From: Daniel Carpenter [REDACTED]
Sent: 31 March 2025 12:14
To: Planning.Responses <Planning.Responses@arun.gov.uk>
Subject: RE: Planning consultation on: BR/249/24/PL

Please see Private Sector Housing comments below. These comments are in relation to Houses in Multiple Occupation (HMOs) and have regard to the Housing Act 2004, The Licensing and Management of Houses in Multiple Occupation and Other Houses (Miscellaneous Provisions) (England) Regulations 2006, The Licensing of Houses in Multiple Occupation (Mandatory Conditions of Licences) (England) Regulations 2018, Arun District Council's HMO Standards, Housing Health and Safety Rating System (England) Regulations 2005 and LACoRS national fire safety guidance

Drawing Title
Proposed Plans and Elevations

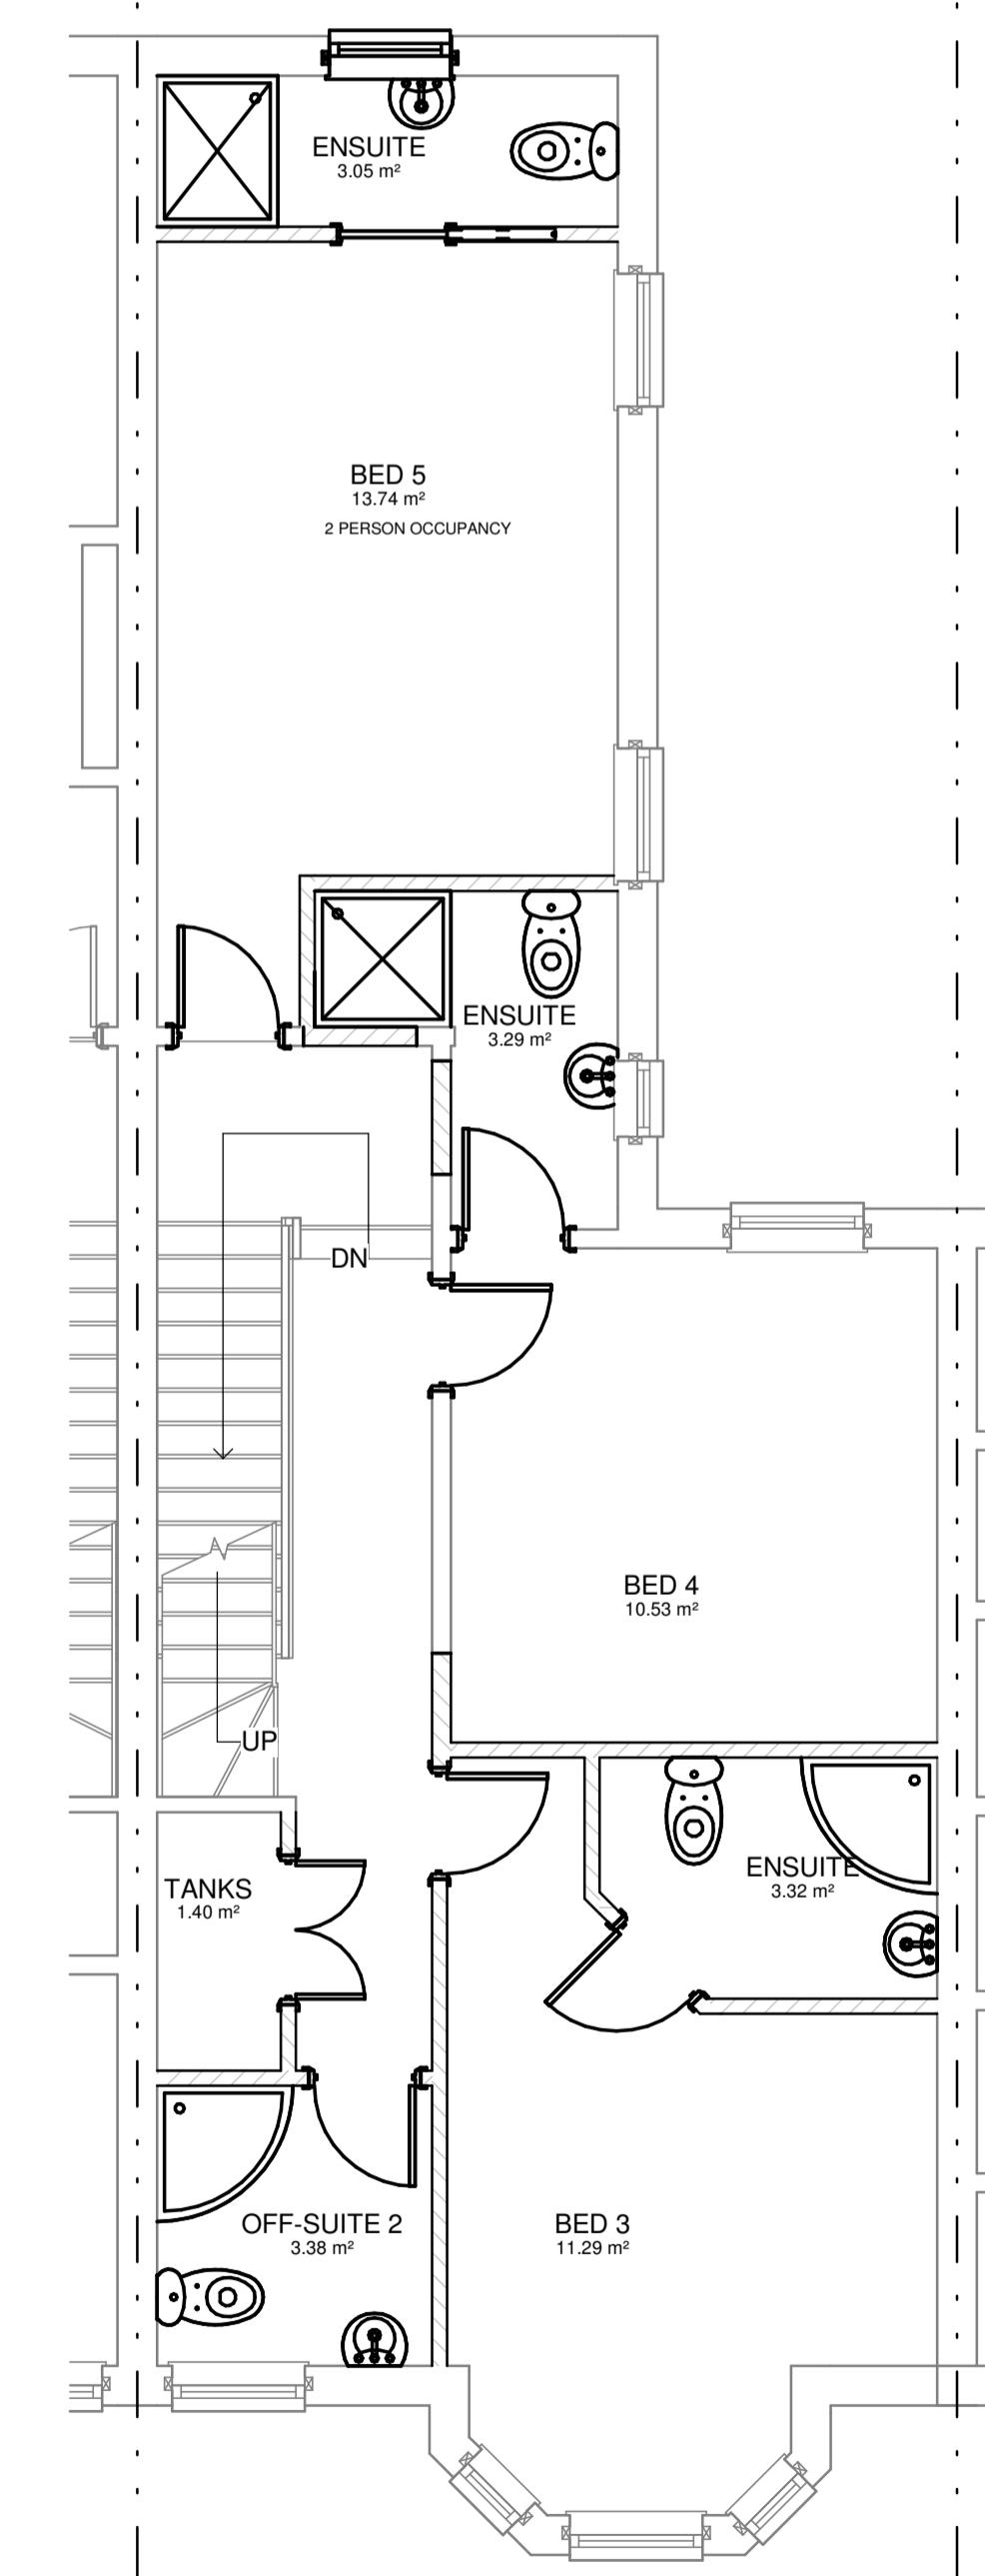
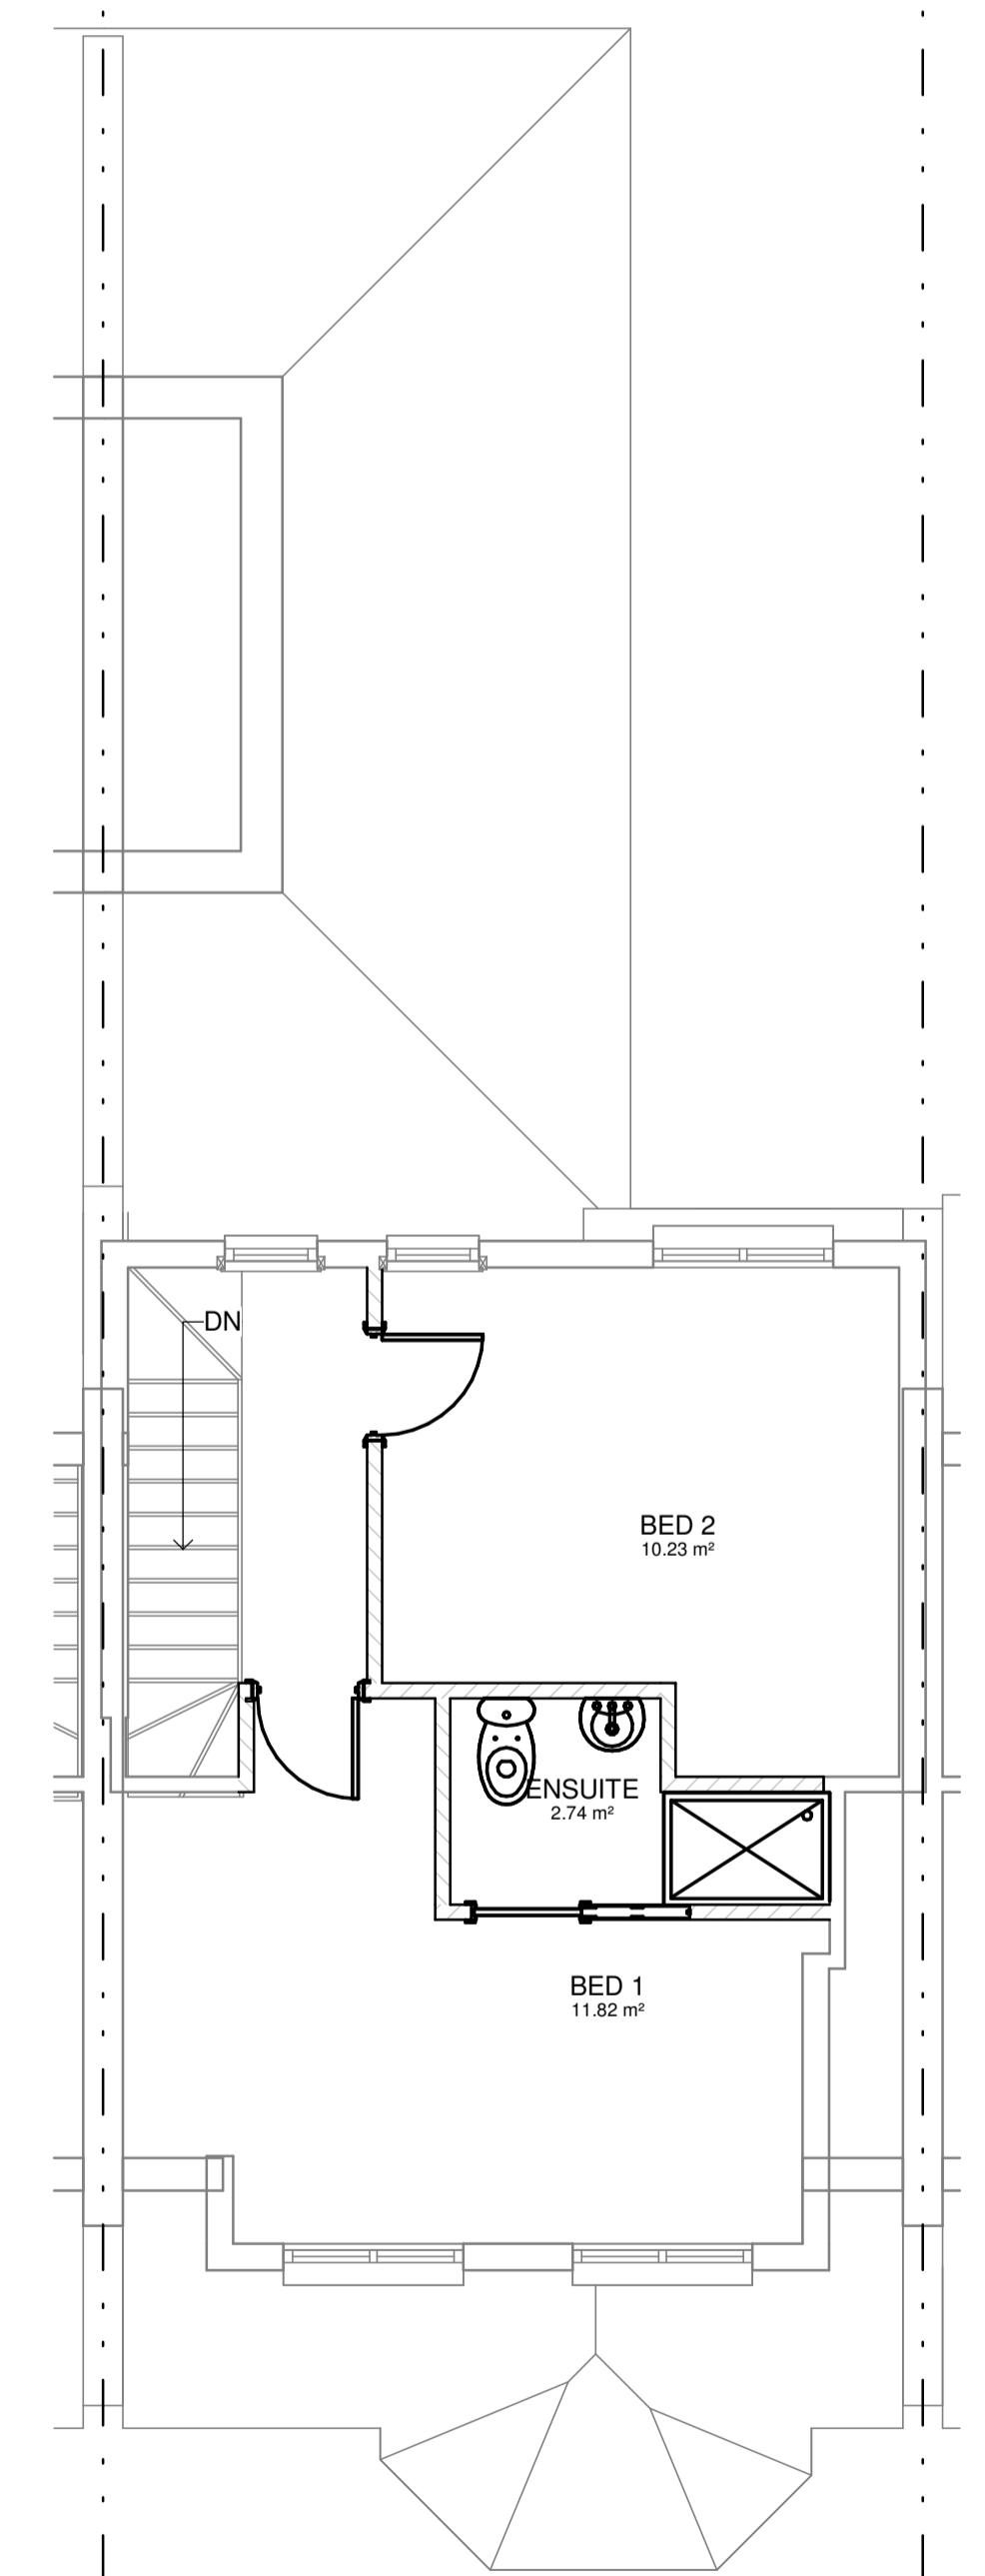
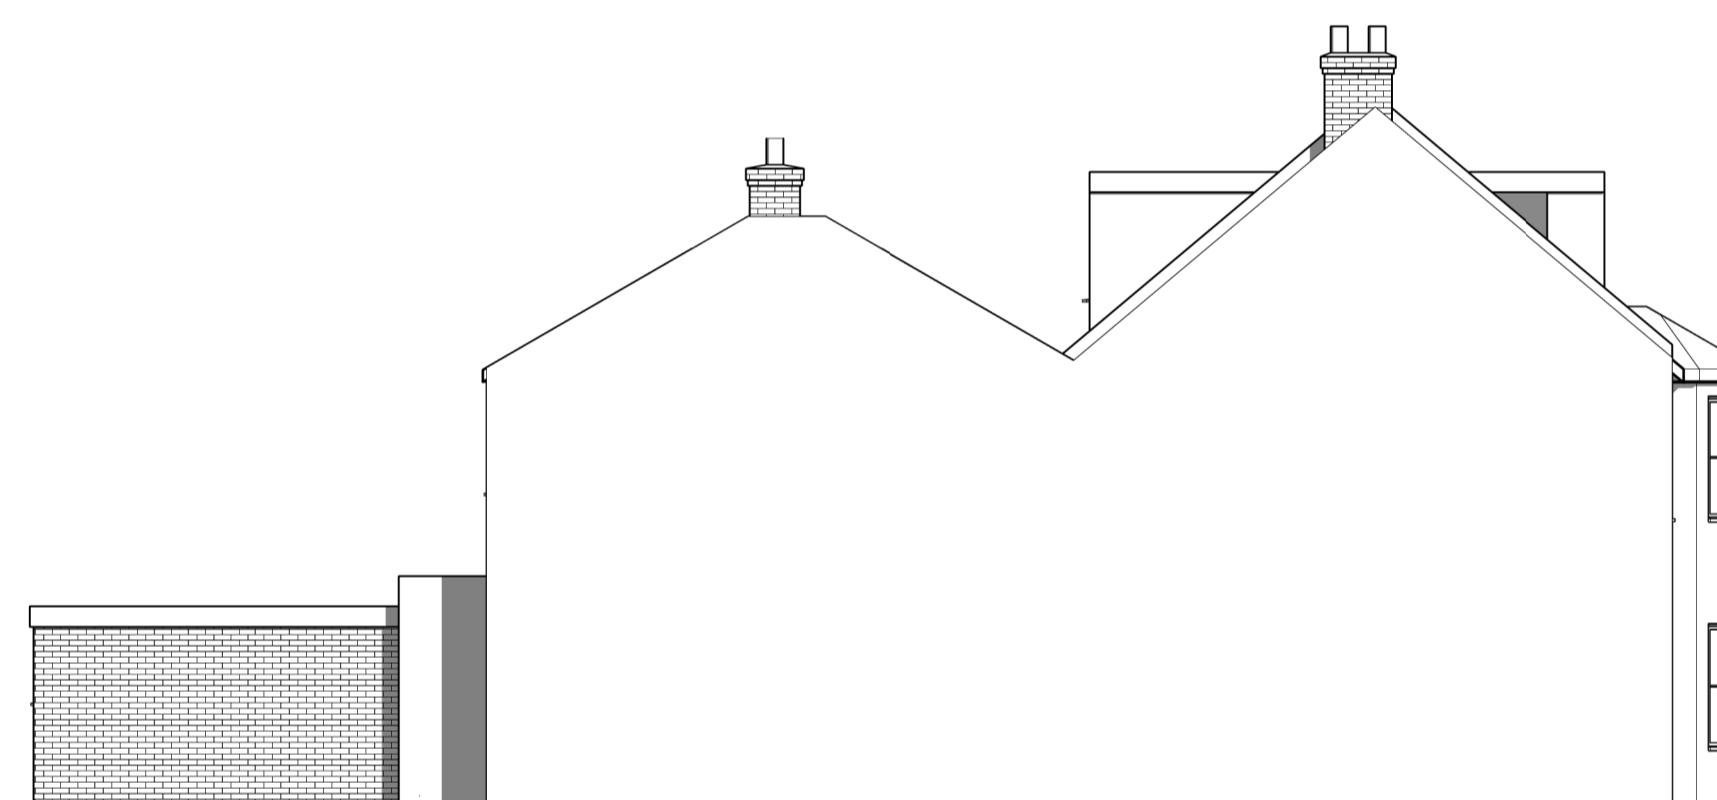
- The proposed plan identifies one shared double sink and a single drainer in the kitchen, for the kitchen to meet the required standard two sinks with their own drainers will need to be provided, or provision of a dishwasher.
- Accessible worksurfaces within the kitchen should be adequate for the number of occupiers living at the residence with a minimum size of 500mm(L) x 600mm(D) per user. Adequate storage space must also be provided which should be no less than 1 x 500mm(W) x 600mm(D) x 870mm(H) fixed floor unit, OR 1 x 1000mm(W) x 300mm(D) x 720mm(H) per user.
